DECISION DELEGATED TO HEAD OF PLANNING

Application No: H16-0727-23 **Applicant:** Mr D Roberts

Proposal: Removal of existing conservatory and replace with one and half storey extension & erection of carport (retrospective)

Location: 75 Bourne Road Spalding

Site Block Plan
1 : 250

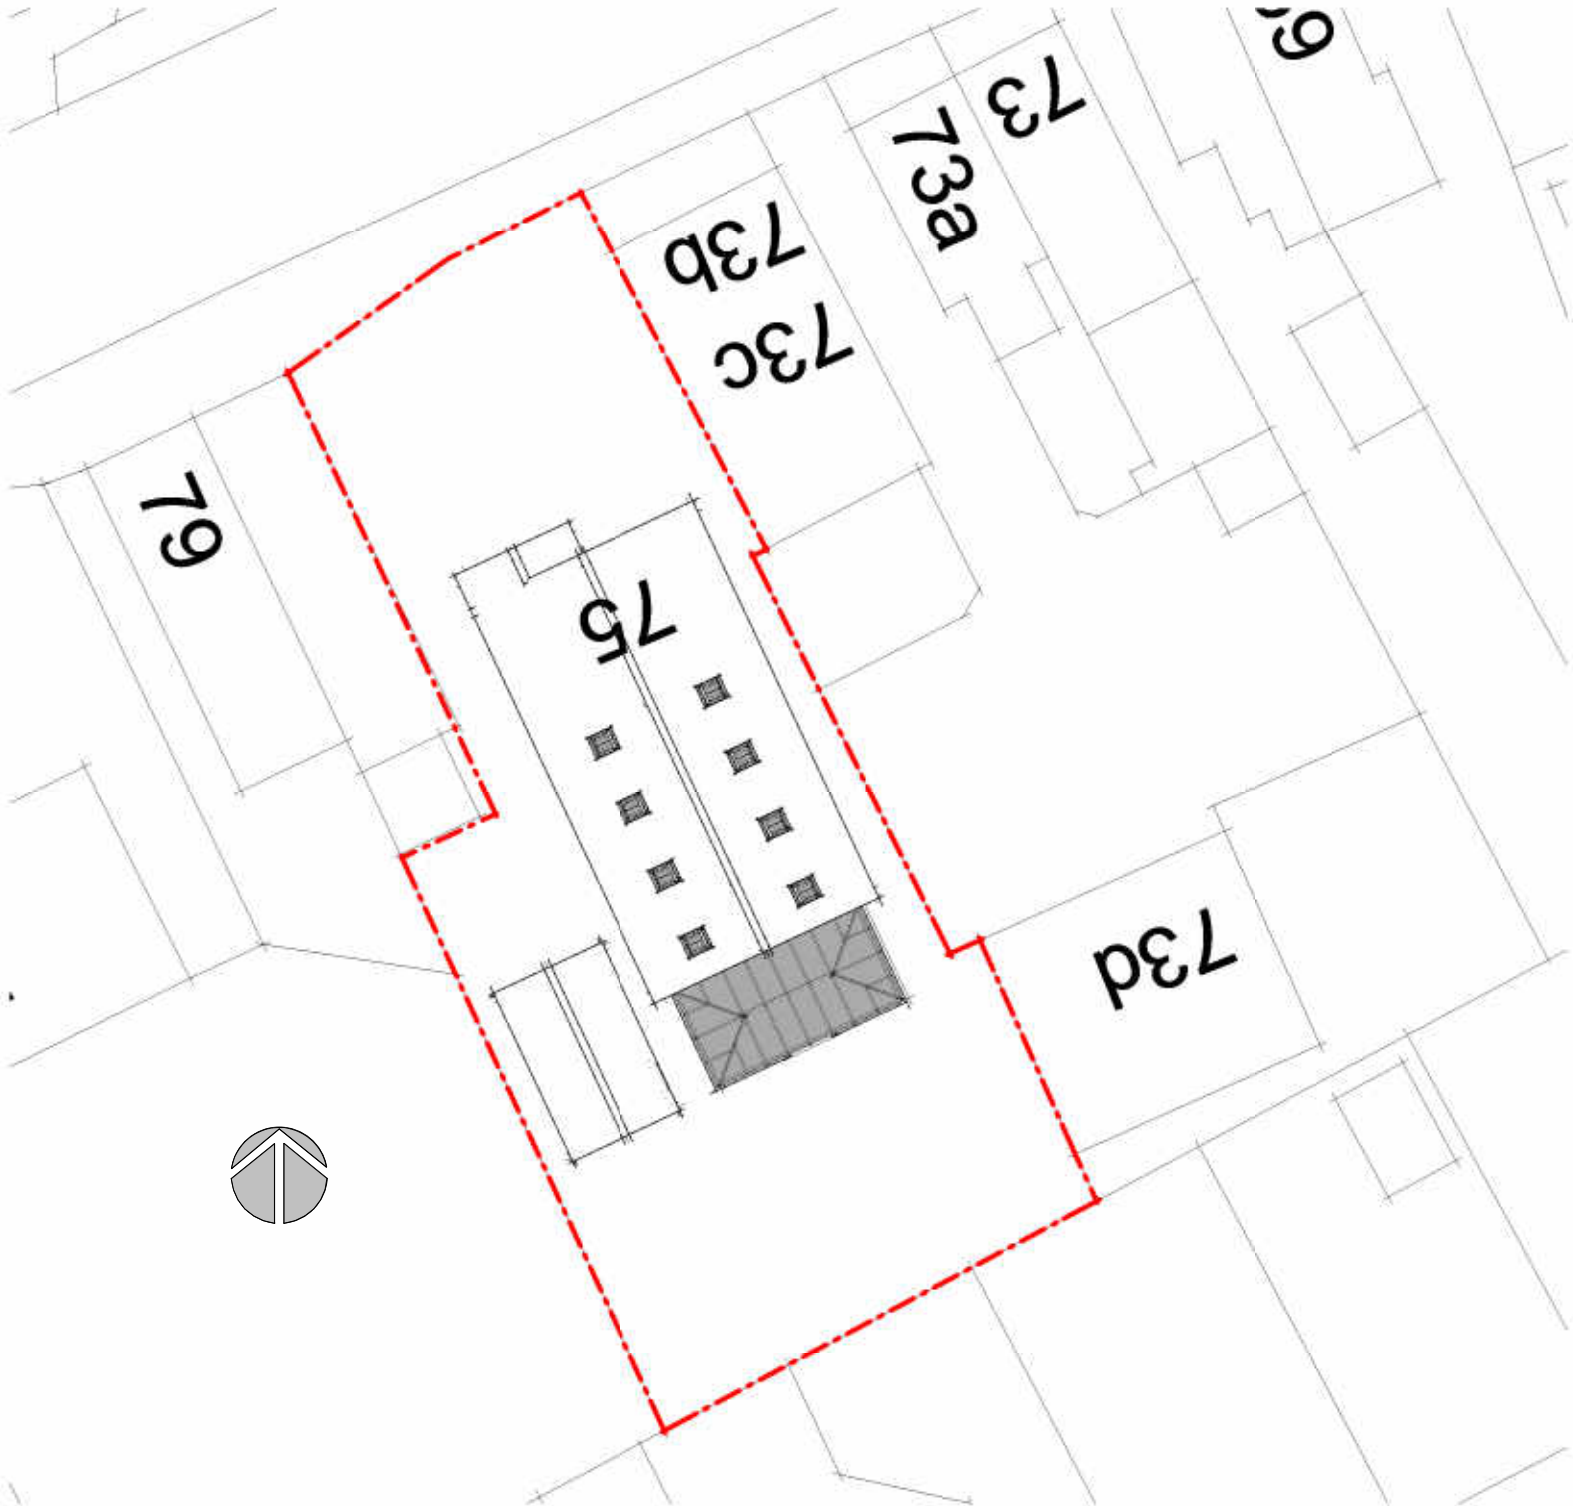
There are currently no other carports in the immediate area, thereby making the proposed carport here a unique feature in the area. The proposed materials likewise are not common in the area. This lack of typicality, coupled with the significant proportions proposed, would lead the carport to being an incongruous feature at odds with the character of the area. The significant scale of the carport is out of proportion to the existing 1 ½ storey dwelling, making it appear even more unwieldy. This significant scale, in particular the height, results in the carport appearing visually dominant, and thus, harmful to the character of the area. The carport is located in front of the adjacent dwellings, further enhancing its visibility and therefore its negative character impact.

However, the carport would significantly reduce the levels of light reaching the adjacent dwelling to the north-east. A separation distance of approximately 1 metre will be present between the proposed carport and the window western facing window of the adjacent dwelling. At this short separation distance, the carport would significantly reduce the levels of light entering this window. As the window connects to a habitable room, and is the sole window in said room, the impacts of losing light here would be felt particularly strongly.

However, the proposed carport would create significant levels of overshadowing. The carport would be approximately 1 metre from the window of the adjacent dwelling, and therefore, would restrict light from entering the property. The proposed use of timber, at such a scale, would introduce an alien material at odds with the area. Carports are not present in the area, and therefore, the introduction of these feature appears incongruous. These concerns are exacerbated by the significant scale of the proposal, drawing further attention to the carport and making it appear even more out of character.

Proposed Elevations

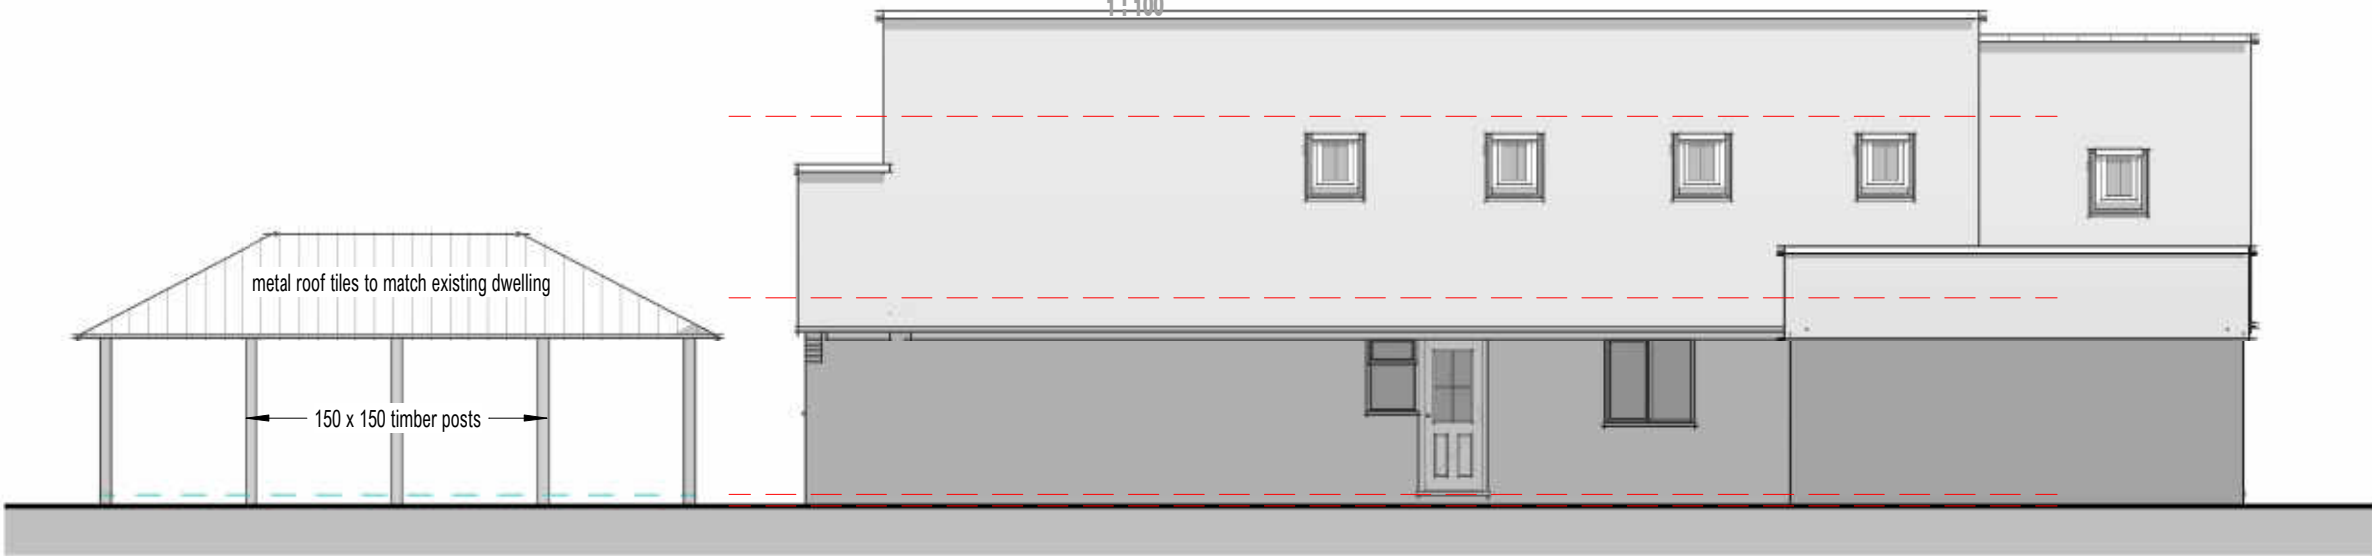
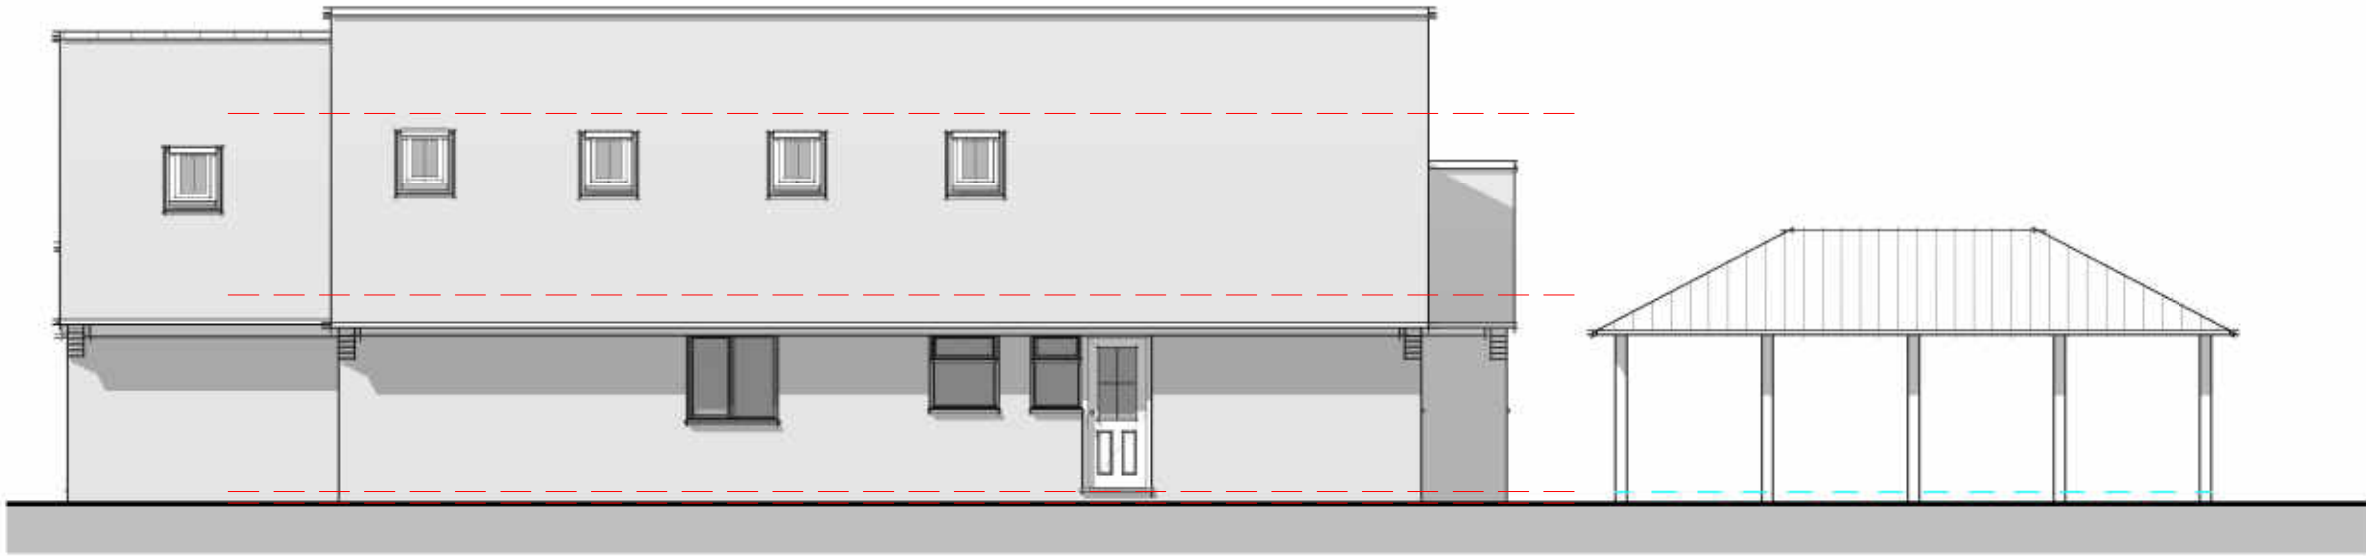
The extension would protrude from the rear by 3.6 metres, and extend marginally beyond the side elevation, forming a connection to the garage. This would provide a total width of approximately 8.4 metres. The extension would feature a dual pitched roof, with design and eaves height in keeping with the host. The ridge would be approximately 0.5 metres less than that of the main dwelling, reaching 6.1 metres. All materials would match the host.

The proposed extension would not increase overlooking concerns. Any views offered by the proposed skylights would be at oblique angles and are not expected to increase overlooking concerns. A window is proposed in the rear elevation; however, this would be in the same position as the existing rear facing window and would connect onto a bathroom. As the window would connect onto a bathroom, it is reasonable to request that the window be obscured to prevent overlooking and maintain privacy.
